**Consultation Response from Mike Hibbert,
KC Waste Strategy(Refuse & Recycling)**

2024/92302 Huddersfield Bus Station, Upperhead Row, Huddersfield, HD1 2JN

Responding Ref: WPS 24-075

Drg. no.
HBS-ECS-Z0-SL-DR-L-00001

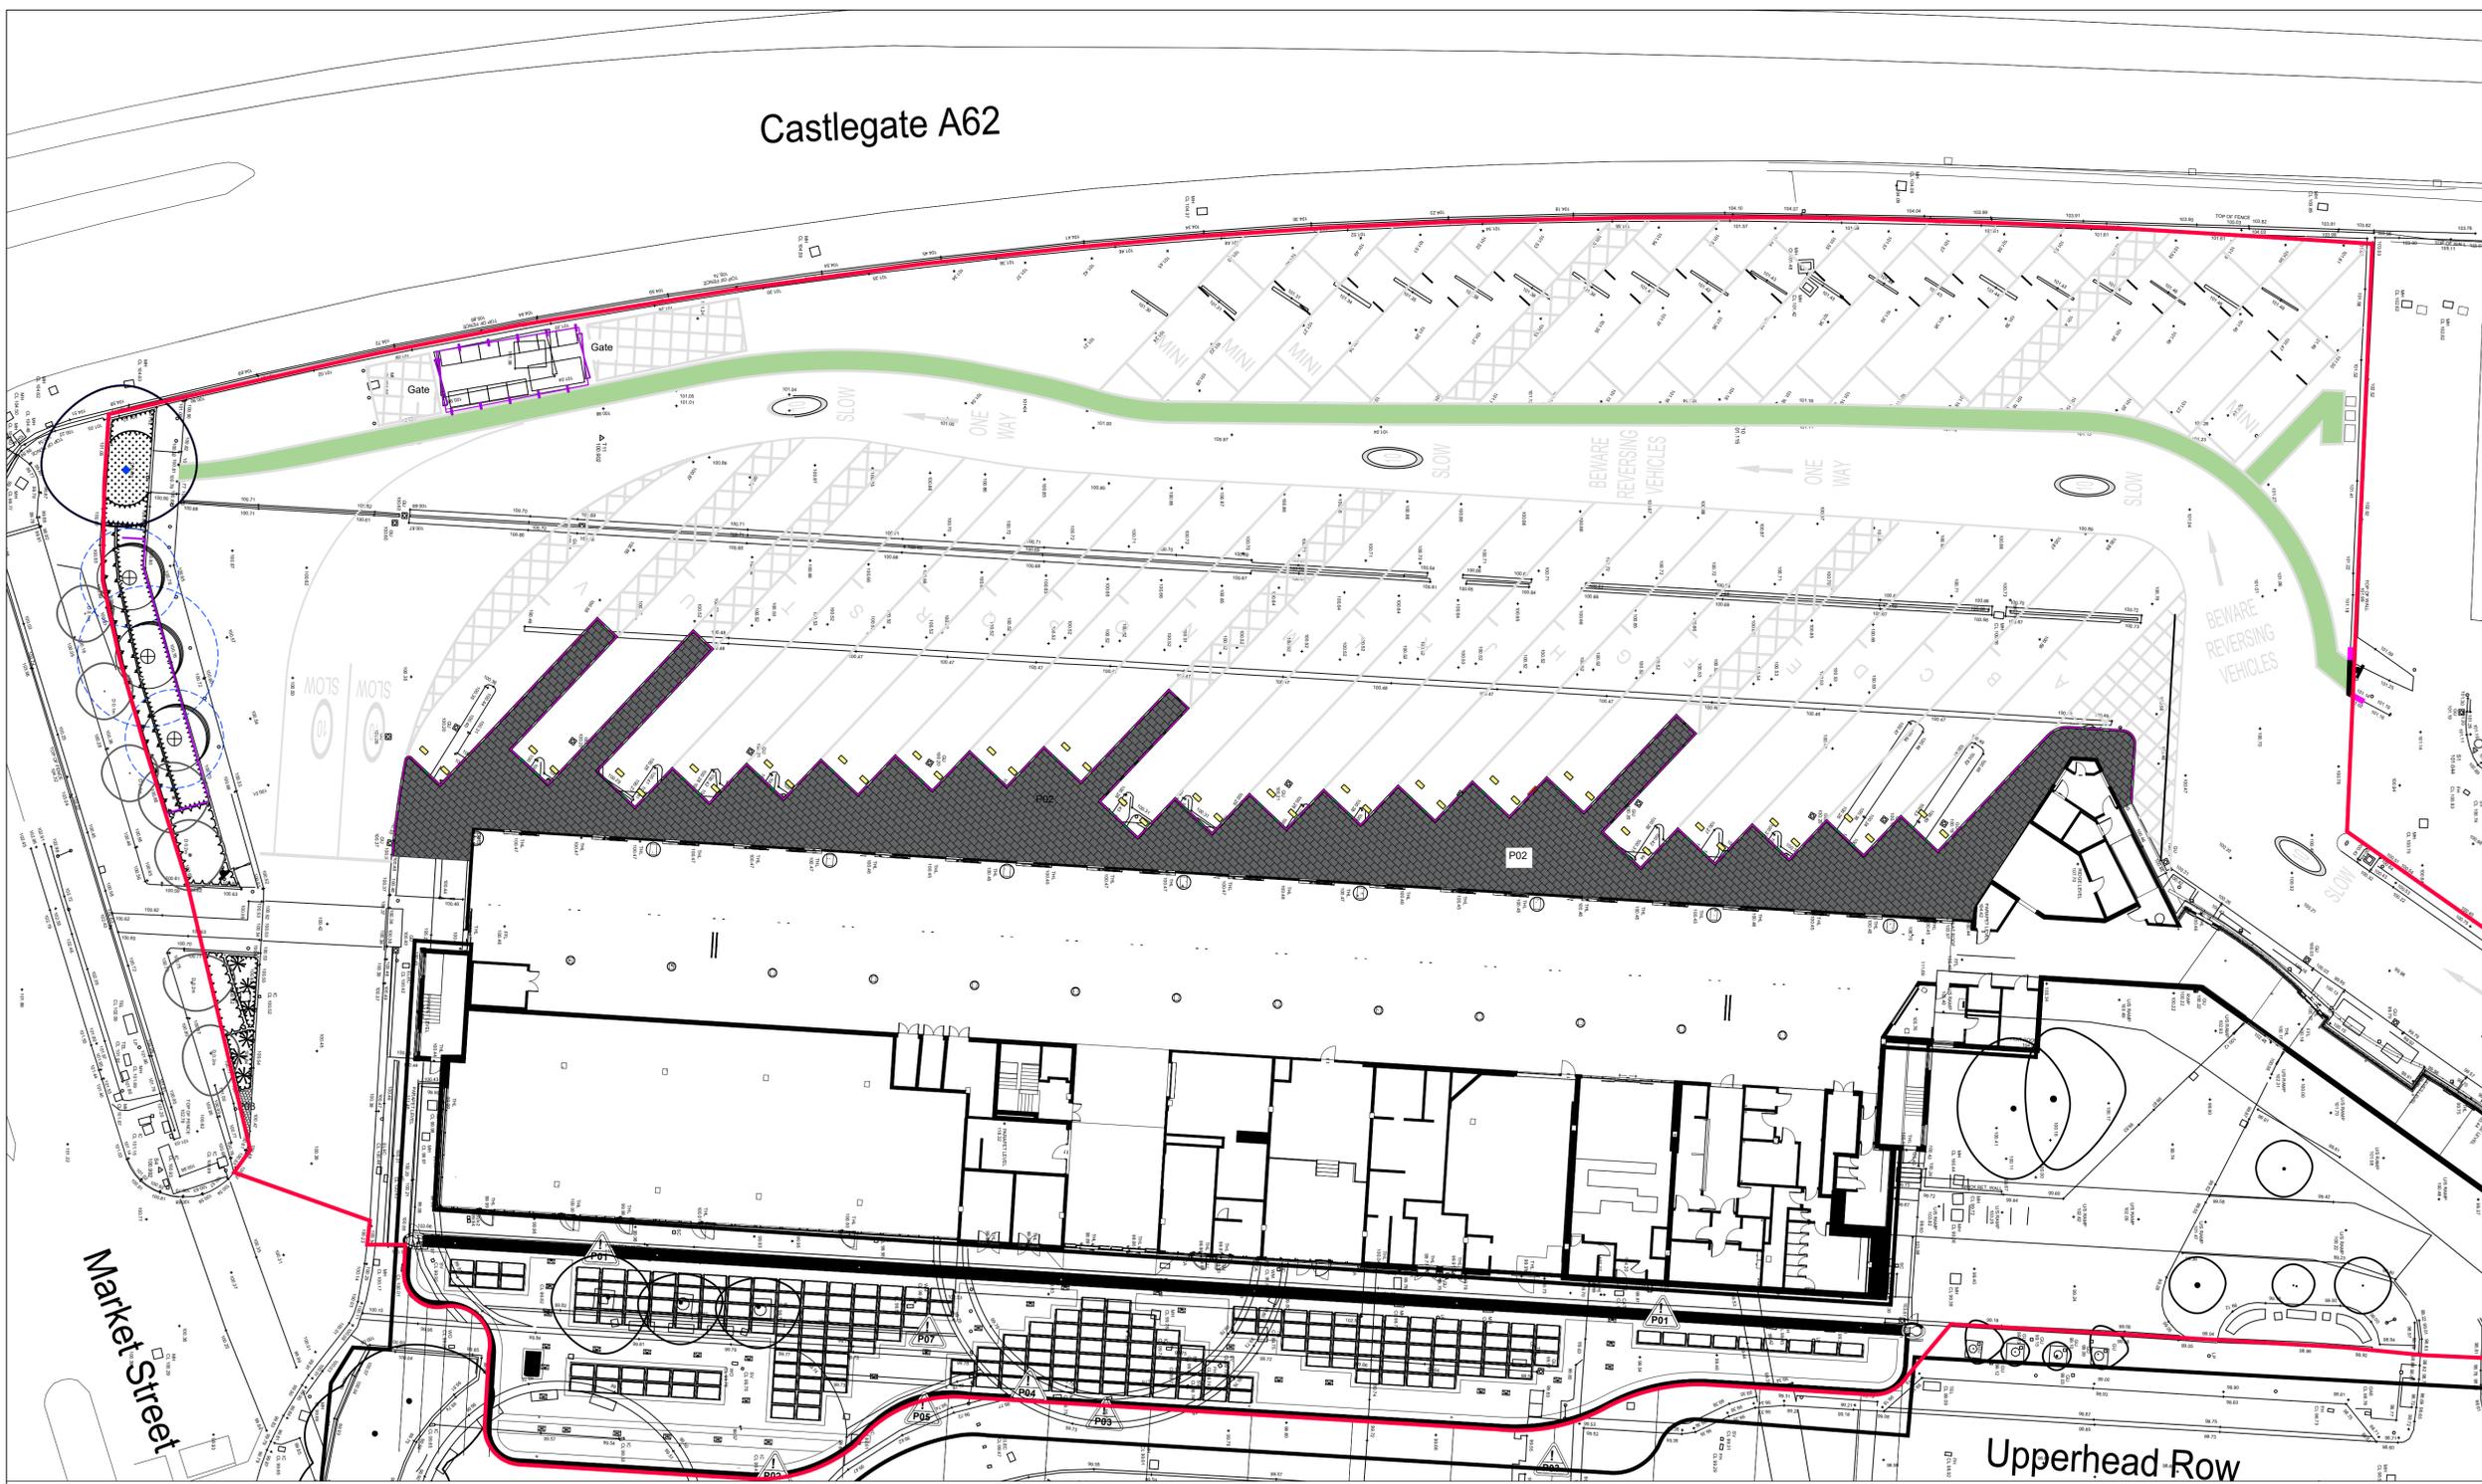
Bin store design drawing HBS-ECS-Z0-SL-DR-L-00004-P02 - Bin Store dated 25.06.24 Shows the design, specification and screening of the bin store. These proposals are acceptable.
